Submission No.			315		
Organisation Name or Name of Submitter			Woodies DIY retail store, Seatown Road East, Swords, c/o Grafton Group PLC		
Item No.	Section Ref.	Page No.	Observation Statement	TII Response	
Submission to An Bord Pleanála, 64 Marlborough Street, Dublin 1, D01 V902 in relation to the Application for a Draft Railway Order for the MetroLink from Estuary to Charlemont, Dublin					
1	2.0 Context 2.0 Previous Public Consultation and Submission	3, 4, 5	As illustrated in figures 1 and 2 below the site will be directly impacted by the proposed acquisition of part of the site for a cut and cover tunnel. We made an objection to the potential CPO of lands on and adjoining the Woodies site during the previous consultation period in May 2019... little changes have been made to the draft Railway Order and therefore there will be major impacts on the successful operation of the retail store. We wish An Bord Pleanála to include this submission as part of our overall objection to the draft Railway Order.	The selection of this route leaves us with limited options to avoid CPO of your property. We have however kept the CPO of land to a minimum requirement at this location. Our plannin

Drawing Title	METROLINK - GENERAL ARRANGEMENT SEATOWN (SHEET 1 OF 3)		Drawing Status	S1
Drawing N°	ML1-JAI-ARD-ROUT_XX-DR-Y-03012	Plan Drawing N°	ML-RO 301 H-J	
Scales Original Size A1	AS SHOWN	Sheet	1	of 1

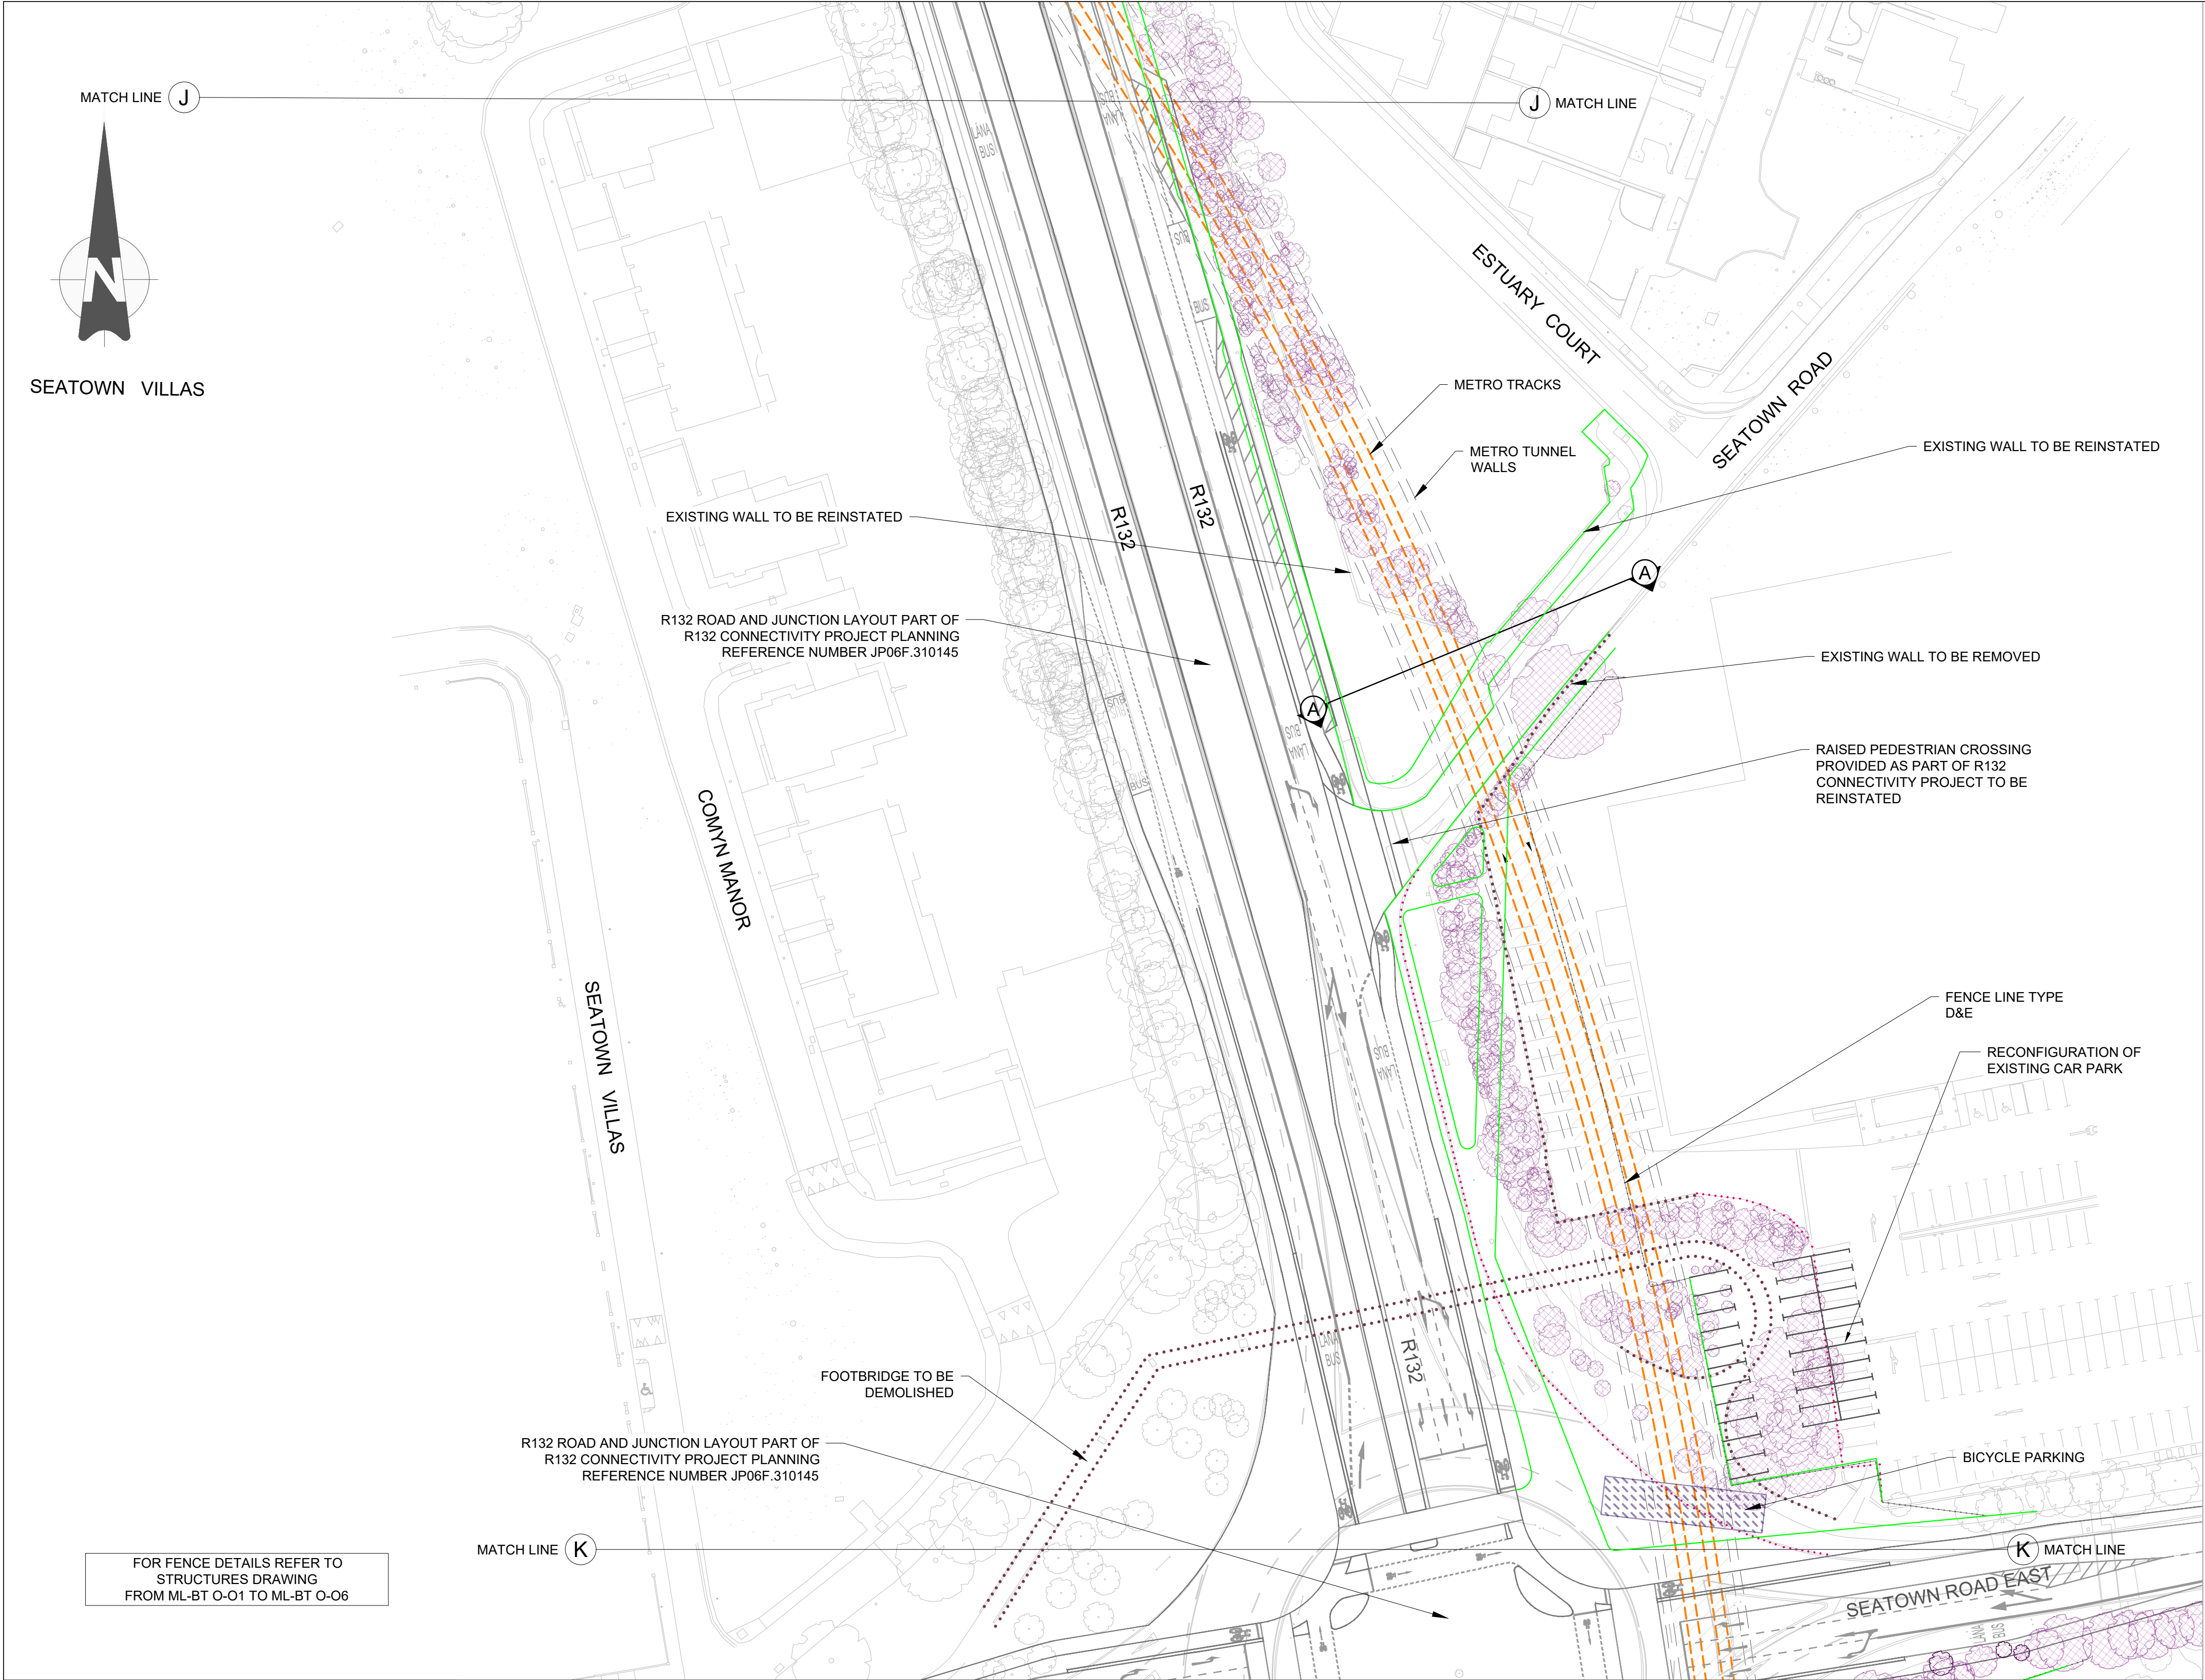
5	3.3 Impact on Car Parking	9, 10	<p>The proposed draft Railway Order will result in the loss of approximately 70 no. car parking spaces (42% of the number of car parking spaces) because of the temporary (up to 4.5 years) and permanent CPO of lands. It is difficult to quantify the exact amount of car parking spaces that will be lost, as the CPO maps, for some inexpiable reason, have failed to delineate the number of car parking spaces within the acquired lands.</p> <p>Even if these (replacement) car parking spaces (on the FCC grounds) did become available, there would be a permanent loss of 24% of the car parking spaces available to Woodies. However, the loss of car parking spaces is accentuated by the permanent loss of the 50% of the (external) garden centre space rendering the remaining 50% unusable, requiring an alternative (external) garden centre in the main car park, which will require a further 600 sq. m, or an estimated 30 spaces. The total permanent loss of car parking spaces will be 56 or 33%, even if the spaces proposed on the FCC grounds materialise.</p> <p>A further concern is the proximity of the Seatown train station to the car park. There is likely to be some unofficial park and ride by rail passengers in the Woodies car park, creating additional pressure on customer spaces for the retail store.</p>	<p>67 Spaces have been counted as being lost temporarily due to TTM measures, see figures proposed around Woodies, figures 5.26 and 5.27 of Appendix A9.5. Permanent land take is shown to the west of the main Woodies building ML 1J-A8, A14 and A15 containing 26 carpark spaces.</p> <p>The permanent acquisition of the land parcels listed above is to provide the final landscape across the alignment as agreed with Fingal County Council as part of the consented R132 Connectivity Project and the creation of a linear park along the MetroLink alignment.</p> <p>As the Woodies Car Park is a privately operated car park, responsibility for the future management and control of the car park charging will be Woodies responsibility.</p>

6	3.4 Impact on the Garden Centre	10	<p>...the location and extent of the external garden centre of the store will be severely curtailed to such a degree that it will have to be relocated on the site... ca. 50% of the external garden centre will be permanently acquired. This will affect the entire garden centre, meaning that a new location will have to be found on the remaining Woodies site, meaning the loss of additional car parking spaces, disruption to the business as part of relocation and construction process and impact on the customer experience.</p> <p>The garden centre is an important aspect of the overall business. The impact of its loss and relocation has not been assessed as part of the EIAR accompanying the application.</p>	<p>TII believe the actual impact on the garden centre will be significantly less then 50% as , whilst there is a significant impact on the West side of the Woodies building where a small section of the garden centre is located, there is limited impact on the north end where the majority of the garden centre is and therefore on balance of the total available space, the land take is considered to be less than 50%.</p> <p>See also response number (5) above.</p>

Submission No.			315		
Organisation Name or Name of Submitter			Woodies DIY retail store, Seatown Road East, Swords, c/o Grafton Group PLC		
Item No.	Section Ref.	Page No.	Observation Statement	TII Response	
Submission to An Bord Pleanála, 64 Marlborough Street, Dublin 1, D01 V902 in relation to the Application for a Draft Railway Order for the MetroLink from Estuary to Charlemont, Dublin					
			There is no assessment as to how the restricted traffic flow and diversions will affect the Woodies access. There is no map showing where the restricted movements to and from the Seatown Road East arm on Seatown Junction are located. No information is provided as to the duration of such restrictions.	The temporary traffic management (TTM) proposals around Woodies and at Seatown Road Junction for the Main Works are provided within the appendices of Appendix A9.5 of the EIAR, specifically sheets 472 to 474 within Appendix B. These are also shown on TTM Phase 1 - Figures 5.26 and TTM Phase 2 - 5.27 (Appendix A9.5), with local diversions outlined in Figure 5-28 of Appendix A9.5. Each TTM phase 1 & 2, during the mains works impacting Woodies is between 18 and 24 months.
